January 18, 2023

James Tolman, CPESC
Inspections Plus Inc.
504 El Paraiso Rd. NE Suite B
Albuquerque, NM 87113-1590

**Re: Peaks at Markana Phase 2 -
Erosion and Sediment Control Plan
Engineer's Stamp Date 1/10/23 (B18E029)**

J. Tolman
01/10/2023
CPESC Stamp

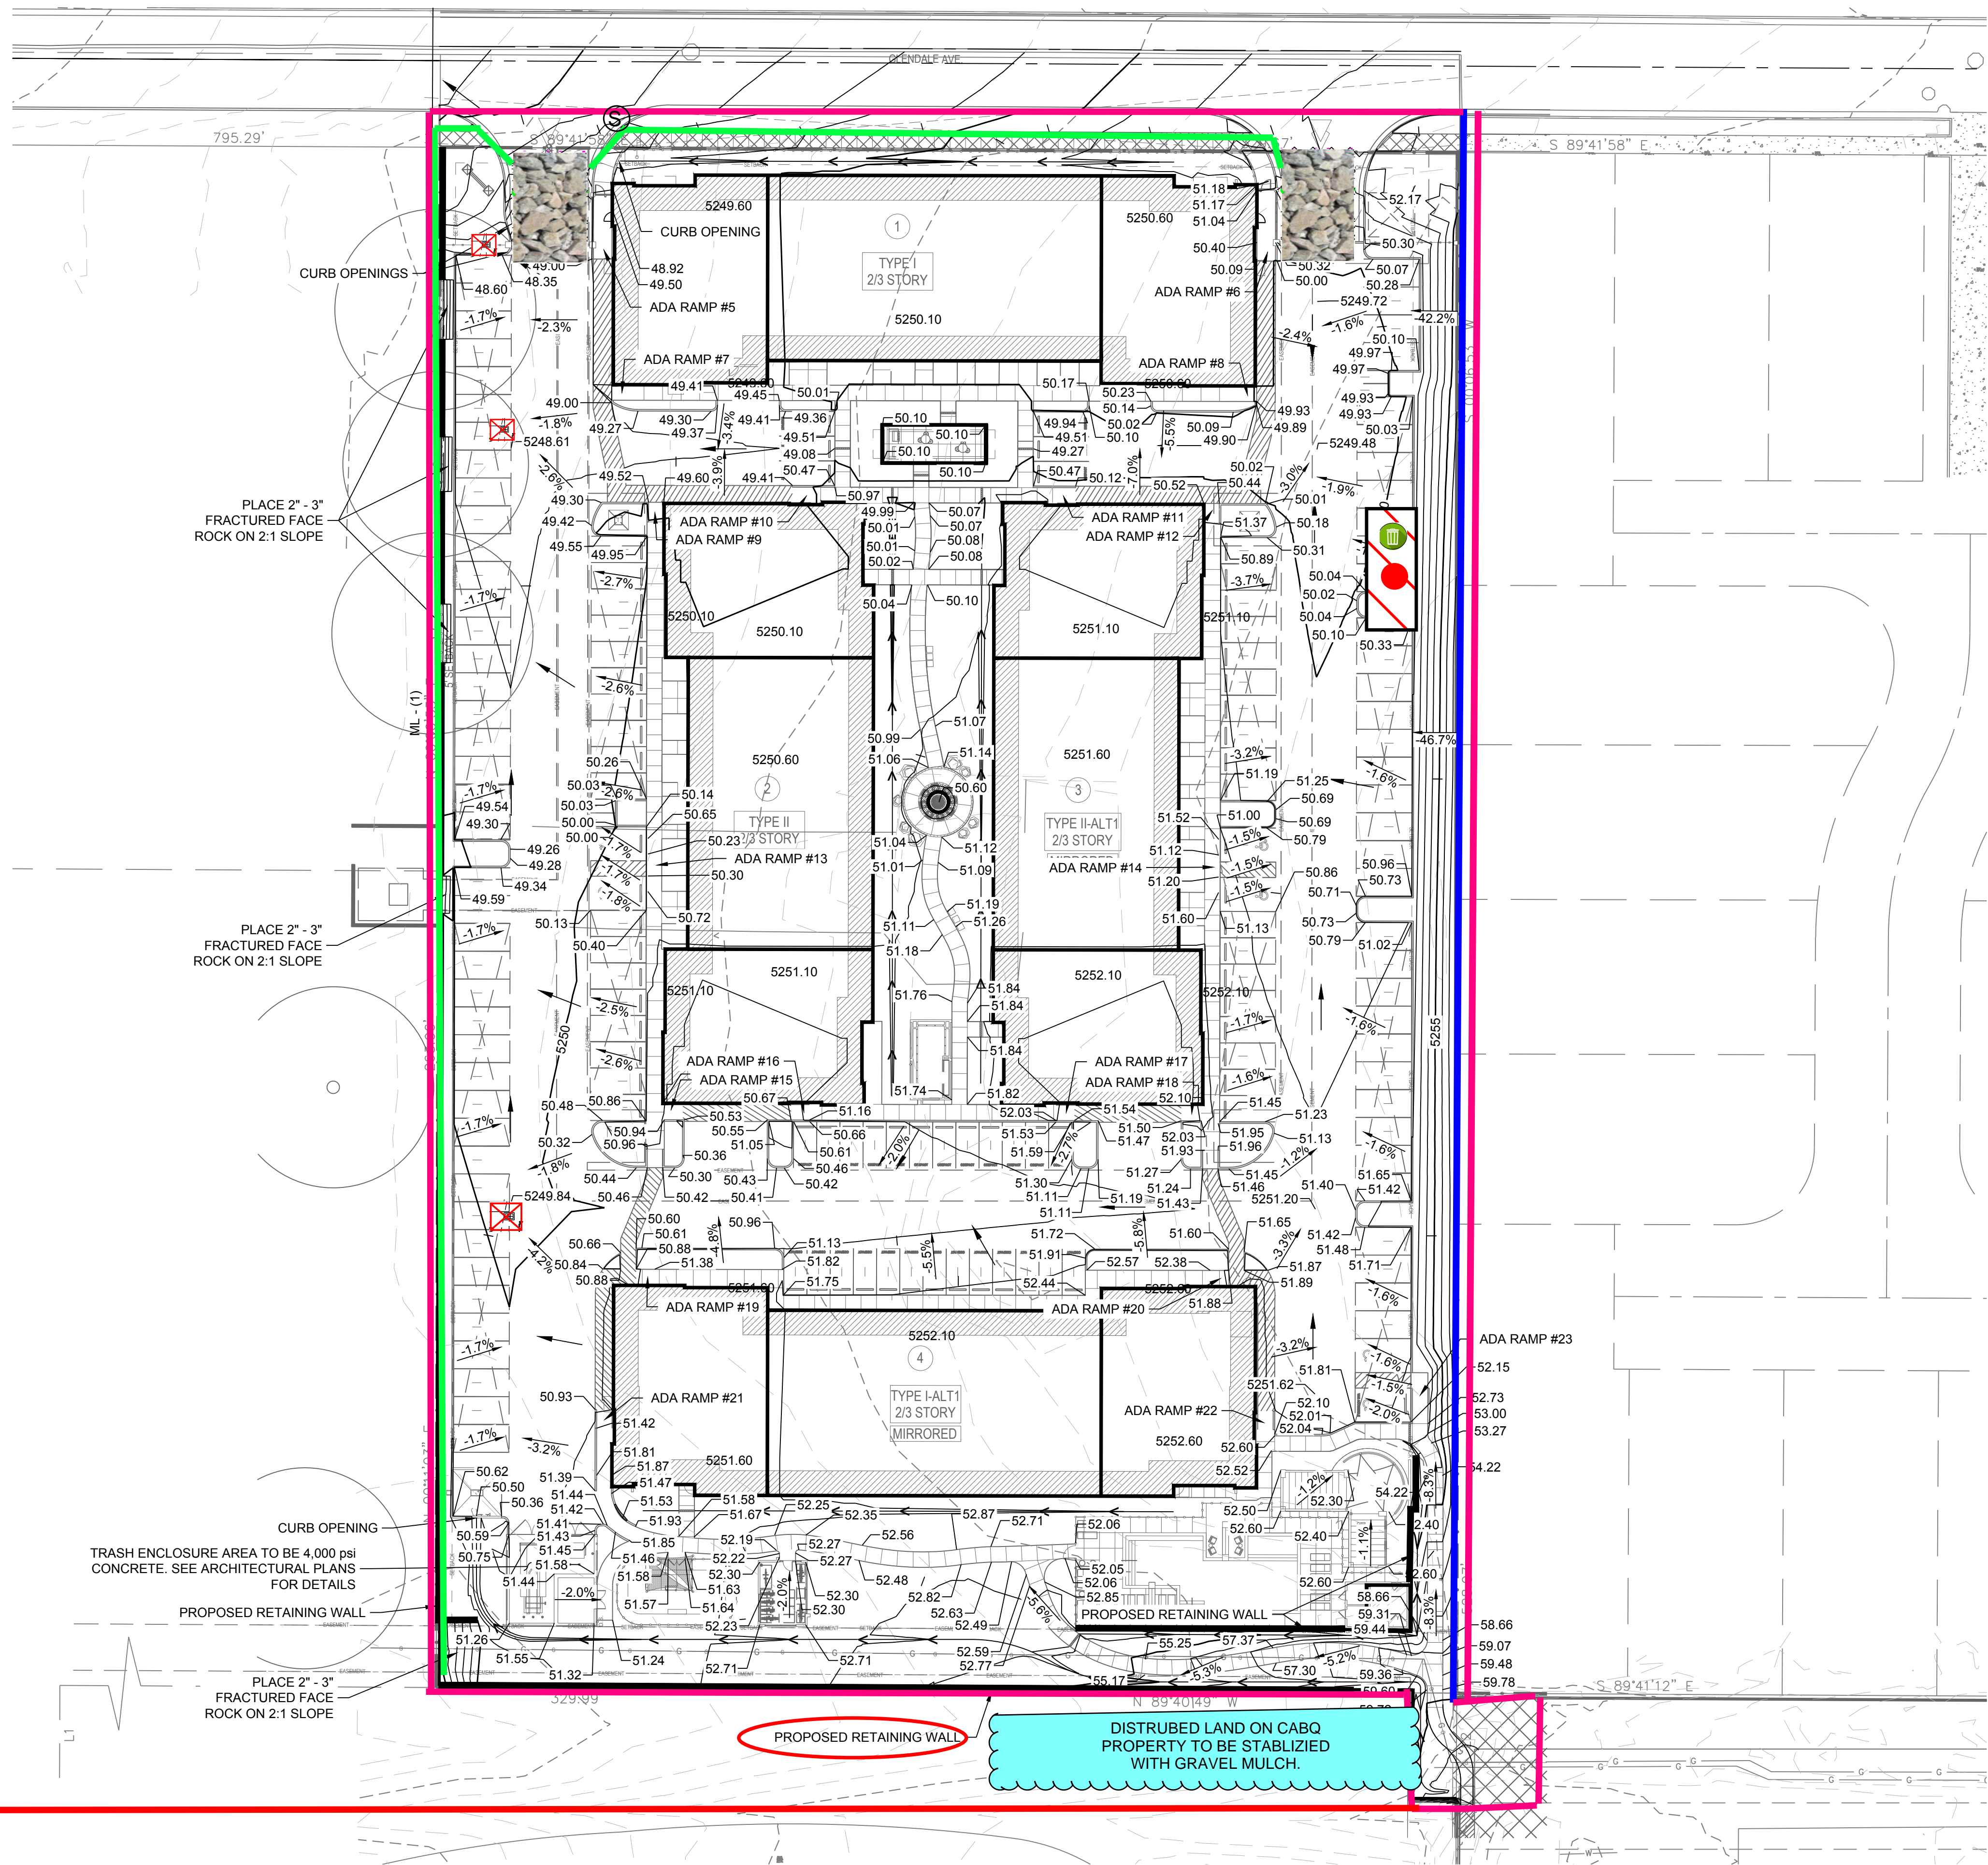
1. The limits of disturbance must include all Work Order improvements on Glendale from San Jose to the east side of this site (CGP7.2.4.b.i). Additional sheets with additional BMPs must be submitted.
2. The NOI must be revised to include the additional area of the Work Order in the area to be disturbed (5.1 acres), and \$500 additional review fees will be required.
3. Update the engineer's stamp date each time the plan is changed.
